Sent: 28 November 2013 13:20
To: Planning
Subject: Comments Added: 12 Ramsey Close Brookmans Park

Application ID: S6/2013/2381/FP Mr M Peacock Application Owner: Welwyn & Hatfield Borough Council (Development Management Officer)

Location: 12 Ramsey Close Brookmans Park Deadline Date: 13/12/2013 00:00:00

Description: Erection of single storey front and side extension and two storey rear extension following demolition of existing garage Comment Added:

Drawing:
**Ground Floor Plan
Proposed**

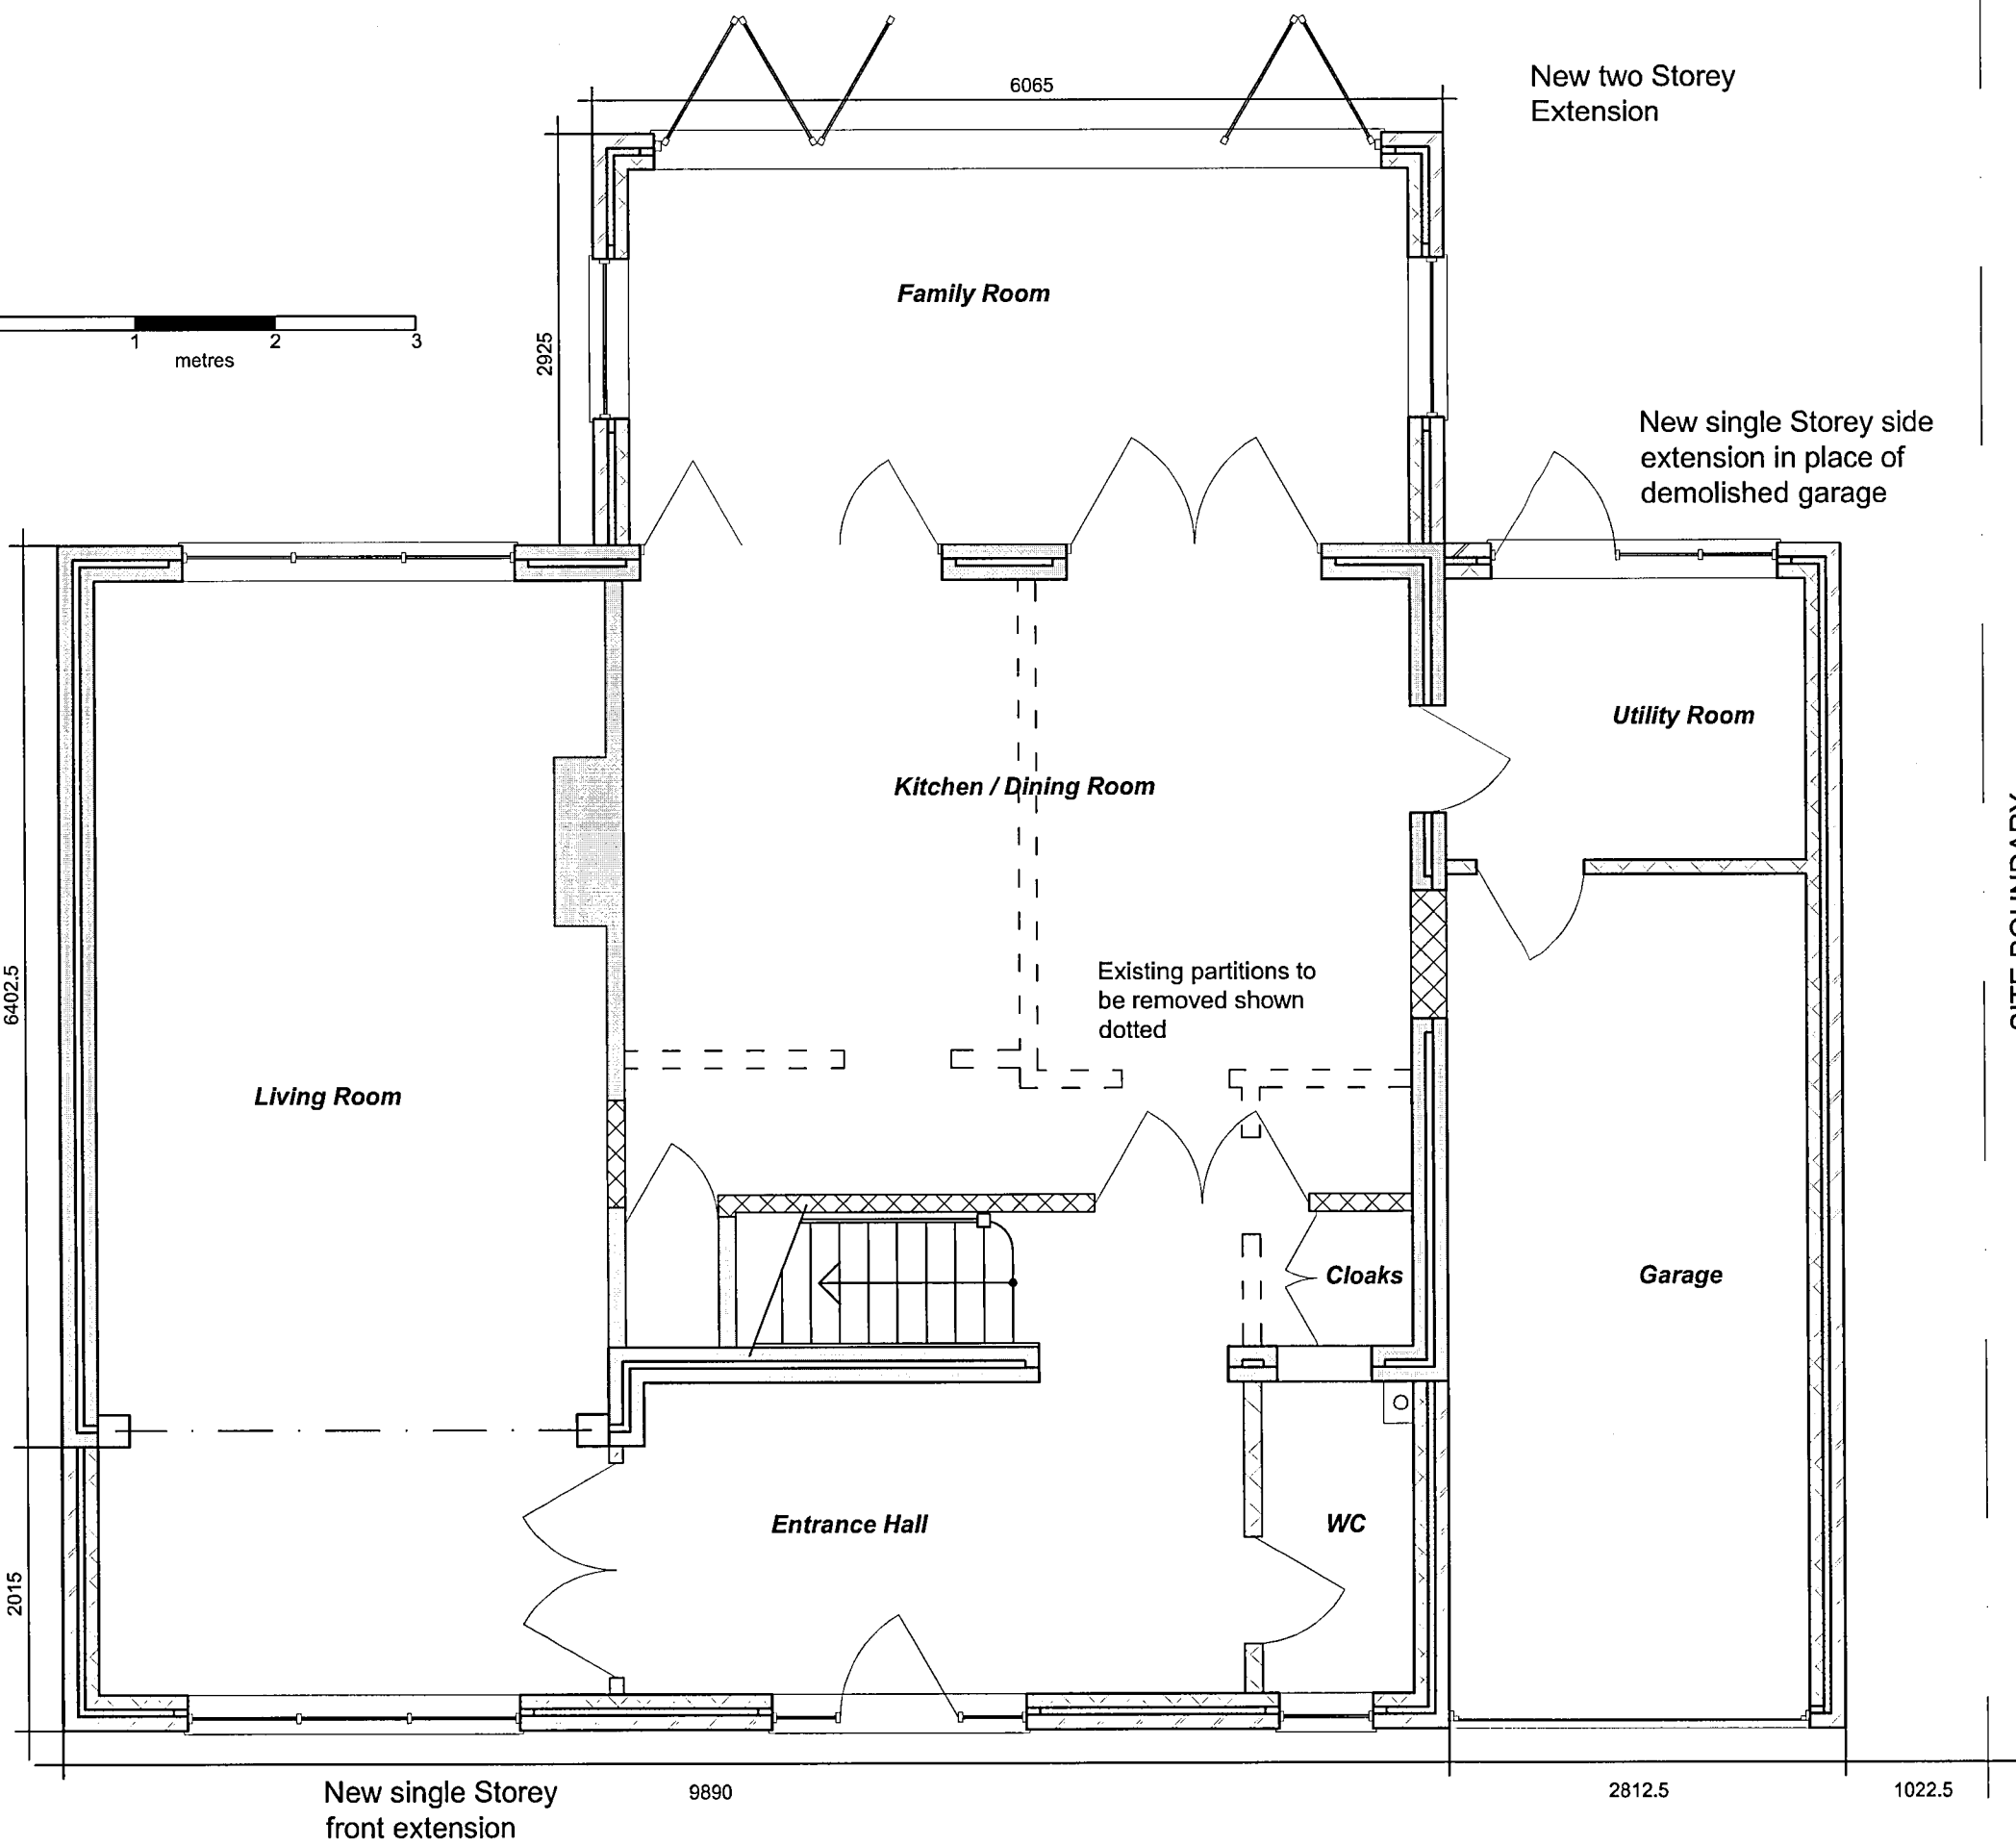
Comment: North Mymms Parish Council considers that the proposed extensions may be overdevelopment in the Green Belt. It should be ensured that the proposal would comply with Green Belt planning policy guidelines on extensions otherwise it would have an impact on the openness due to the increase in volume.
